From: Brothwell, Hannah [REDACTED]
Sent: 13 August 2019 14:52
To: Simon Davis <Simon.Davis@arun.gov.uk>
Cc: Greenwood, Suz K <[REDACTED]>
Subject: RE: West Street Bognor Regis RE: BR/73/19/PL

We have accepted a revised FRA on this application which outlines measures (extra ground raising) to take the site out of the future Flood Zone 3a (our SFRA indicates that the site will be in 3a by 2061). This includes a FFL revised from 5.72m to 5.85m (0.13m increase) and a corresponding 0.13m increase in site levels to a mean of 5.7m. Can you just advise whether this alters your previous comments at all. I need your response before the 14th August 2019 and if I do not hear from you, I will proceed with a recommendation to approve (for our September 4th Development Control Meeting) and will amend the FFL condition to refer to the new FFL.

FLOOD MITIGATION PLAN

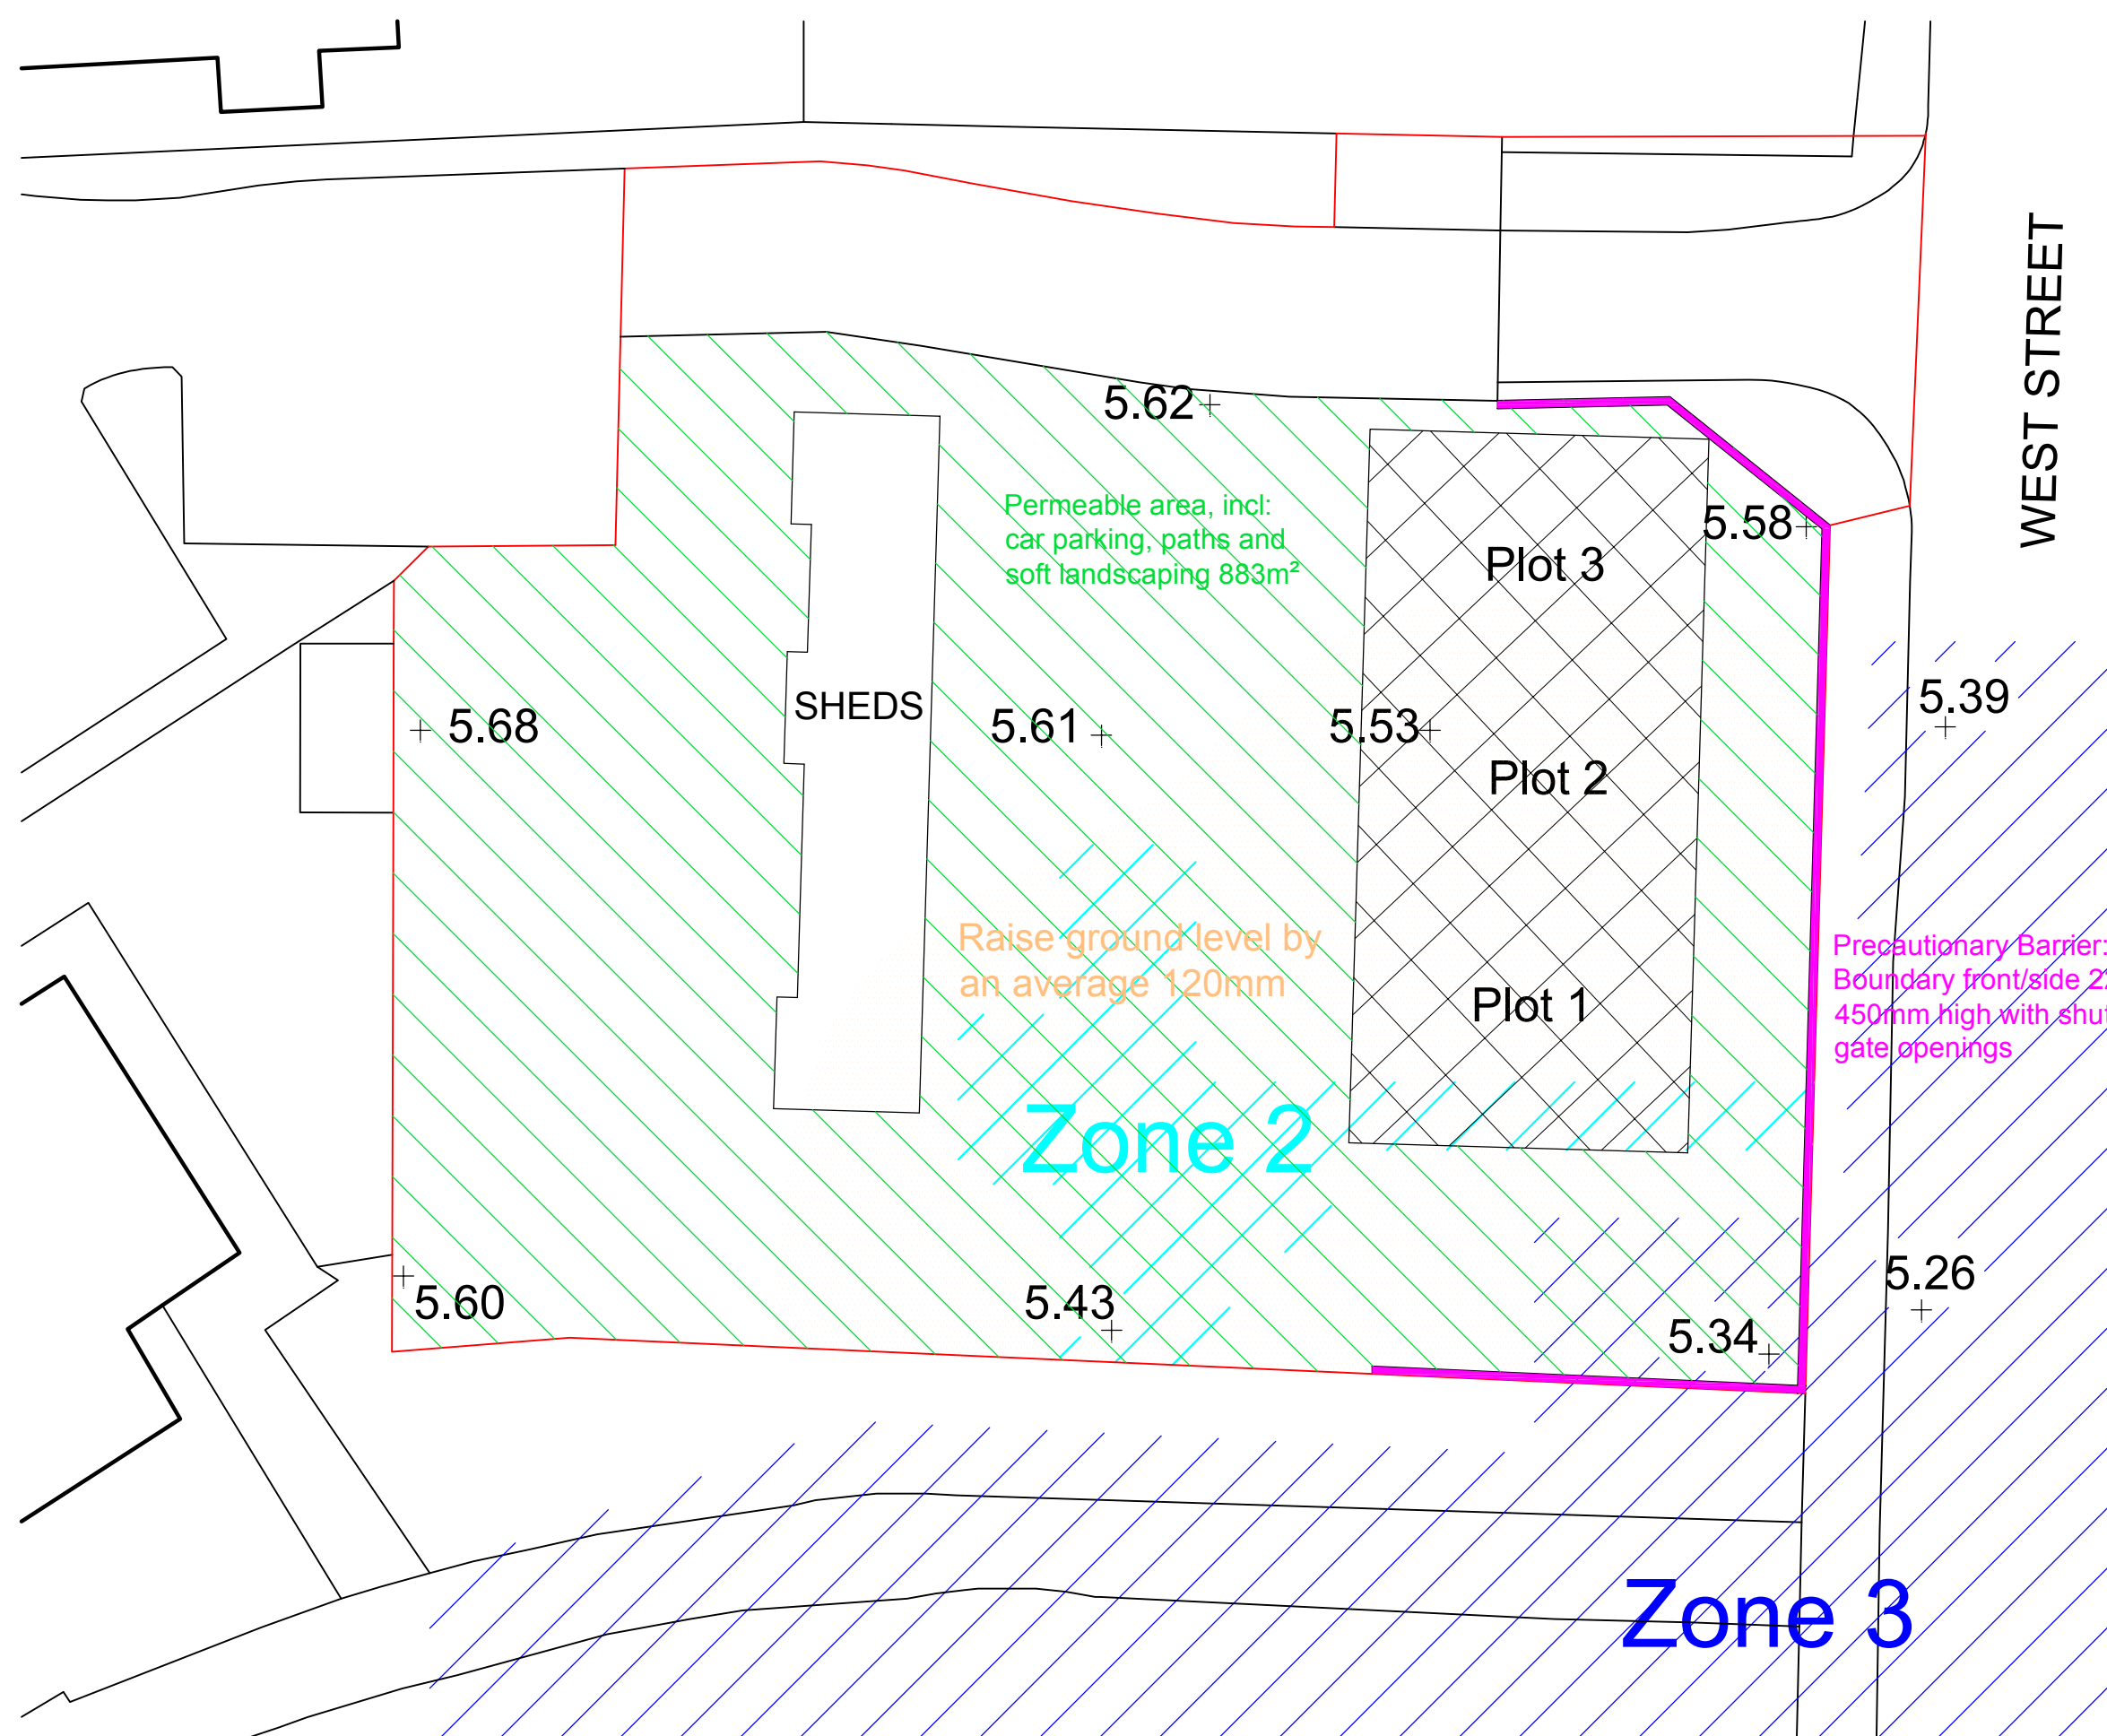
I agree with team leader and addressed the sequential test in respect of 2061 Zone 3a. In addition I have revised the Flood Assessment and Mitigation statement. I have calculated the future zone 3a to a level of 5.6m and raised the ground level overall to 5.7 representing 300mm in the south east corner to 60mm for most of the site.

We've reviewed the information and have no objection on the revised plans of raising FFL an extra 0.13m from 5.72m to 5.85m as this in fact provides an overall betterment in terms of safety of occupants from flood risk. Therefore we are happy for the condition to be amended to the new FFL.
